# Dean Moor Solar Farm

## Applicant Response to D3 Written Representations (1 of 2)

28 October 2025  
Prepared by: Broadfield  
PINS Ref: EN010155  
Document Ref: D4.4  
Deadline: 4  
Revision: 1

Zone of Theoretical Visibility DTM with
View Locations

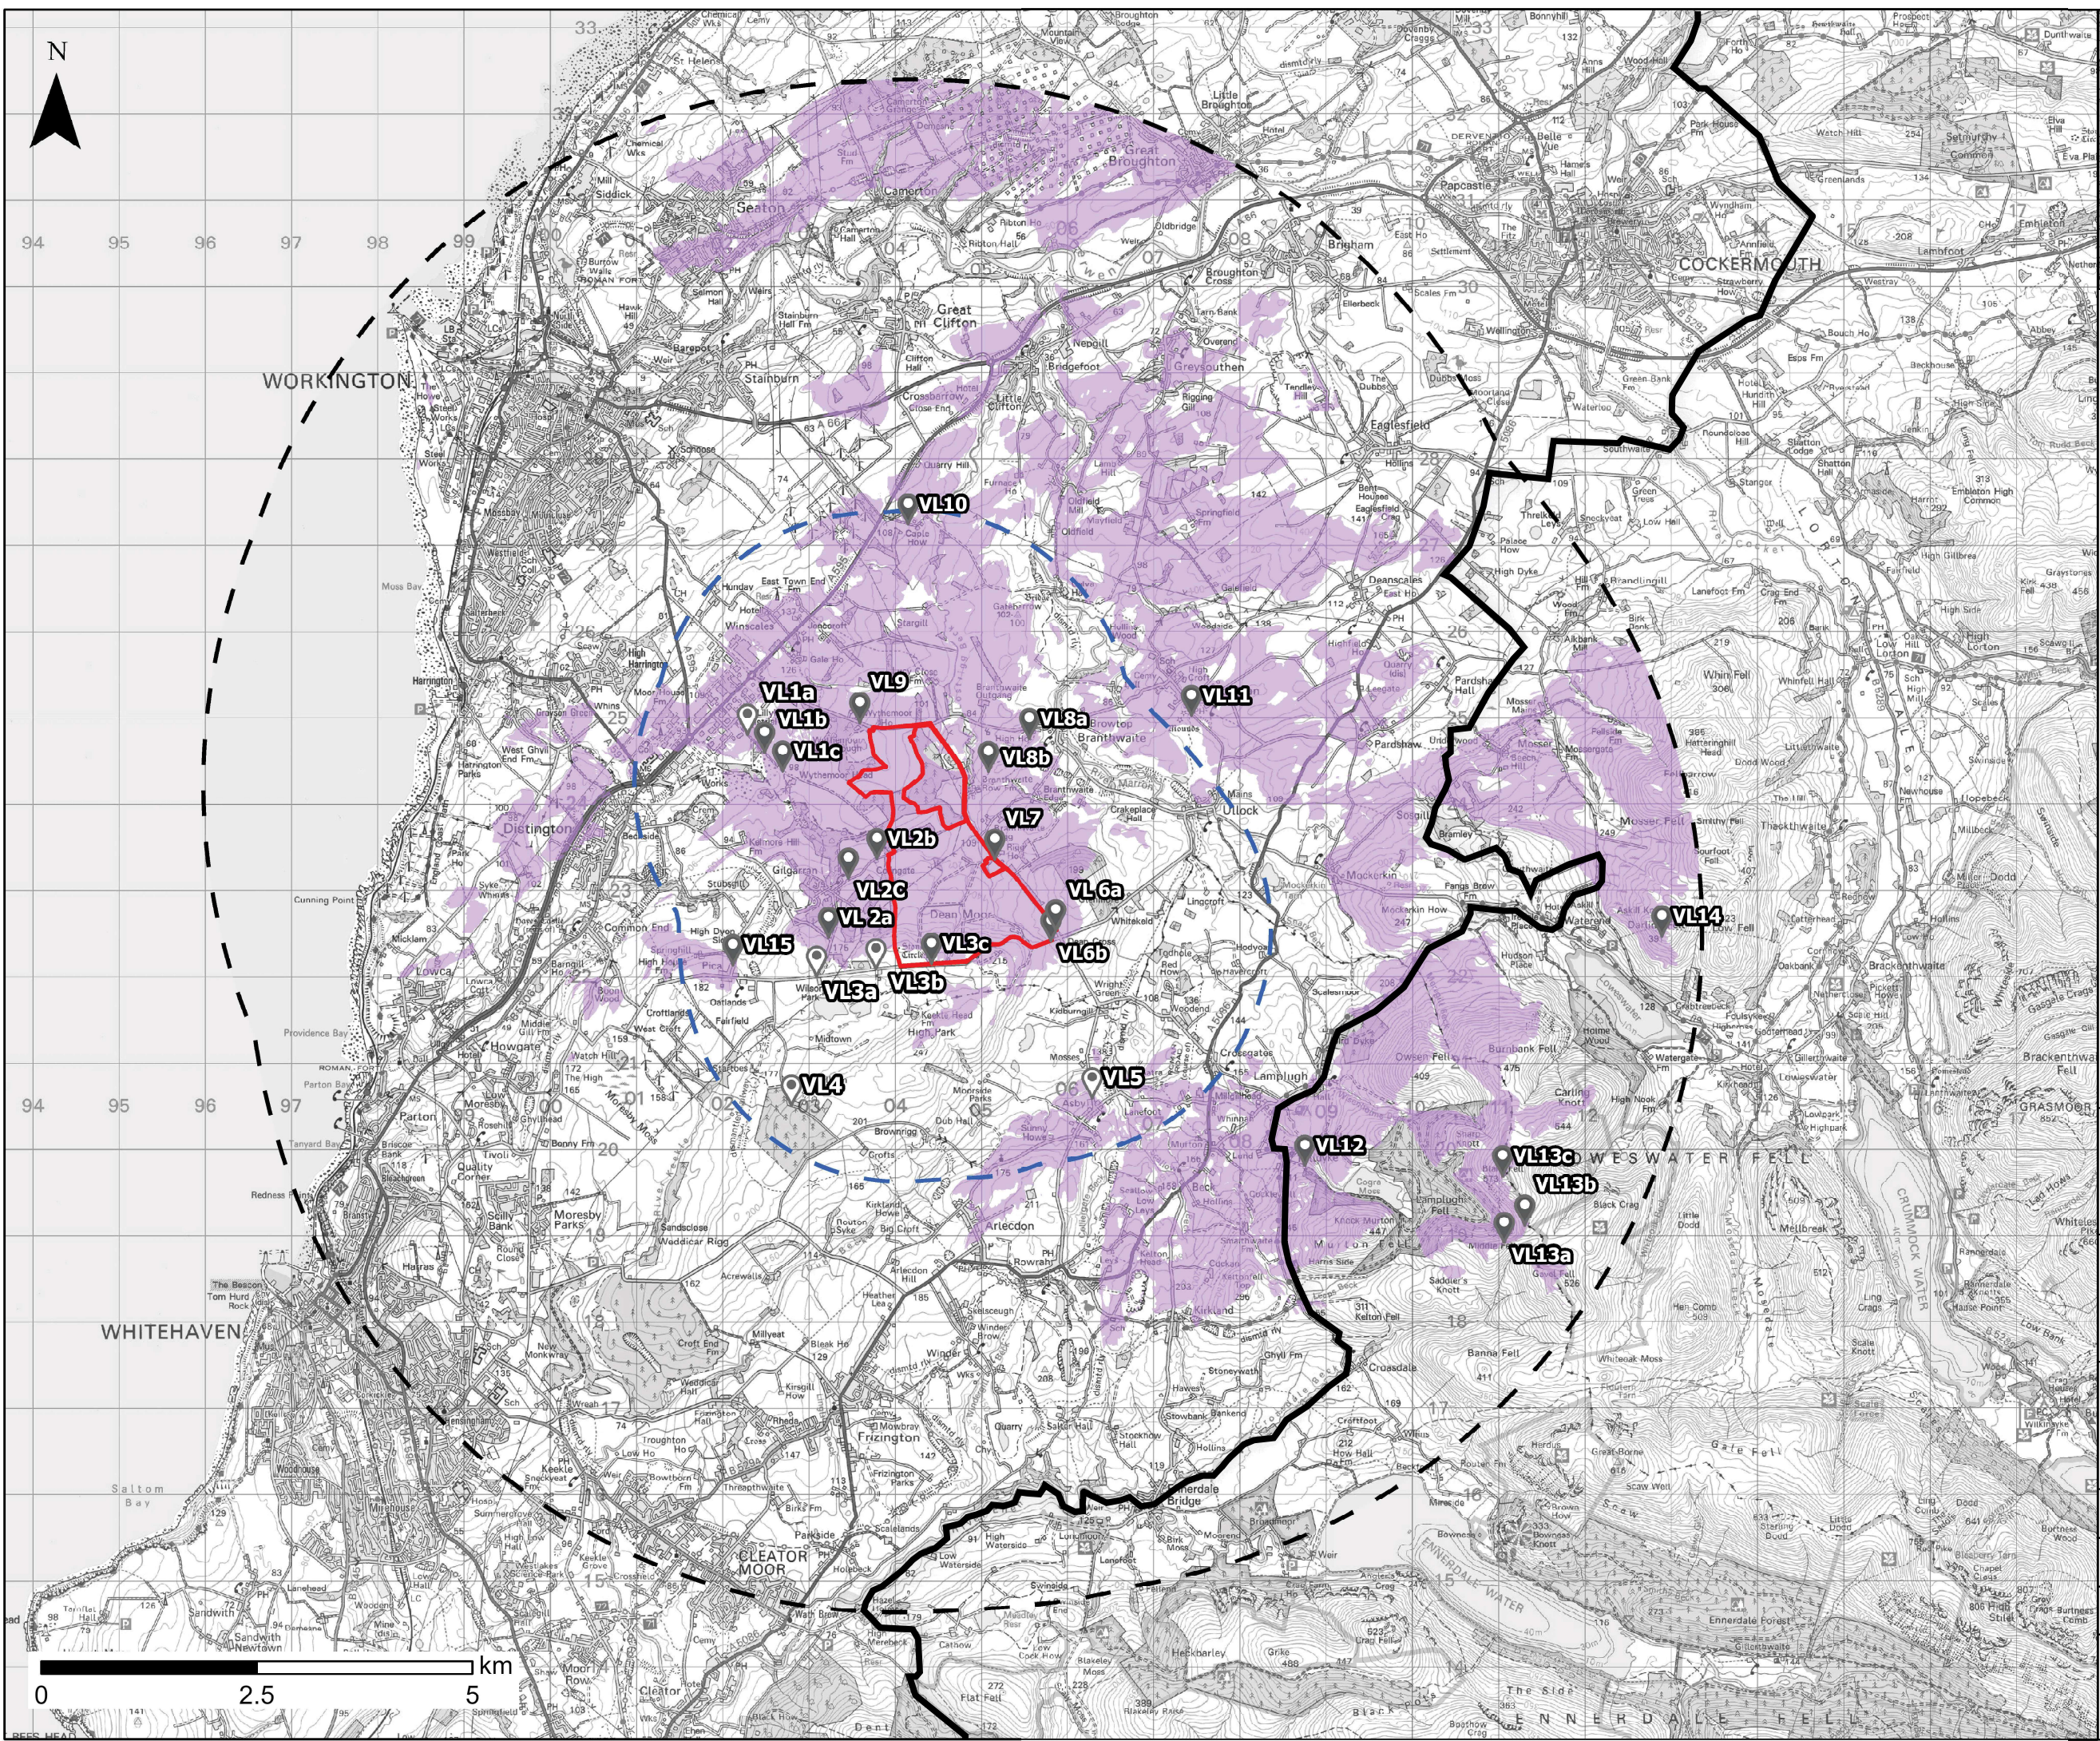
LDNPA Response to the Issue Specific Hearing Agenda Items	Applicant Response
<p><i>2.8 There are only limited views available of the development from locations within the National Park Boundary. The ZTVI mapping that has been provided appears to show a greater area within the National Park than we have observed from our ground truthing, as being affected.</i></p> <p><i>2.9 The availability of views is strongly affected by the local topography. The highest portion of the land lies to the south side, where the ridge of High Park-Branthwaite Edge obscures views from the south. The ridge is less effective in screening views from the fell tops identified below due to the ability of the viewer to see over the ridge. Our assessment however is that views from valley level within the National Park (Mosser, Loweswater, Lamplugh, Cogra Moss) would be unaffected by the development, due to a combination of intervening screening, glimpsed views of parts of the development site and distance.</i></p> <p><i>2.10 The particular views we have identified as being affected are:</i></p> <p><i>1. Fellbarrow (represented by viewpoint 14): The fell is included in the Wainwright Western Fells book (included in the 214 'Wainwright' summits). Fellbarrow stands between 8 and 9km west from the site. The view from the summit is described as: 'Fellbarrow stands on the fringe of the high country, and to the north and west there is a wide and uninterrupted view of the coastal plain of Workington and district and across the Solway Firth to the Scottish hills, a scene predominantly rural but with some obvious evidences of urban development and industry'. Parts of the site are visible from the summit and the upper western flanks. Due to the position of Branthwaite Edge, the main portion of the site (Area C) would be less prominent from this location, the areas A and B would be more visible.</i></p> <p><i>2. Blake Fell and Burnbank Fell (represented by view points 13, 13a and 13b): Blake Fell and Burnbank Fell are also included in Wainwrights Western Fells book, Blake Fell being 'the highest of the Loweswater uplands', and as such is a popular climb. Again, views seawards are described as uninterrupted and 'the West Cumberland coastal area is revealed in detail'. These fells stand 7-8km south west of the site. Parts of the site are visible from the summit and the upper western flanks including the subsidiary summit of Knock Murton. From the summits views are available over the intervening ridge to a substantial portion of the site.</i></p> <p><i>2.11 Having regard to the distance of the views available towards the site from the fells, we consider that the detail of the development including individual structures would not be apparent. The principal change would be that of a change of colour: from green fields to blocks of grey panels, and a sense of developed versus undeveloped character to the land. We consider that the assessment of this effect has to have regard to the overall size of the site and development. At 279ha, the site is substantial.</i></p> <p><i>2.12 At present, the 'evidences of urban development and industry' in this part of the West Cumberland plain are mostly focussed to the west, on the coast and around Workington. Lillyhall Industrial Estate extends this sense of developed character south and eastwards and the proposed site would be almost contiguous with Lillyhall. We consider that the effect would be to stretch the sense of developed land into the rural area and towards the National Park. This sense would be</i></p>	<p>support the landscape and visual impact assessment and the VL for which visualisations have been prepared is included in LDNPA.2 and 3 of the dSoCG [<a href="#">REP3-017</a>].</p> <p>The LDNPA's position is consistent with the advice provided during statutory consultation, which is described within Table 7.2 of ES Chapter 7 Landscape and Visual [<a href="#">REP2-032</a>].</p>
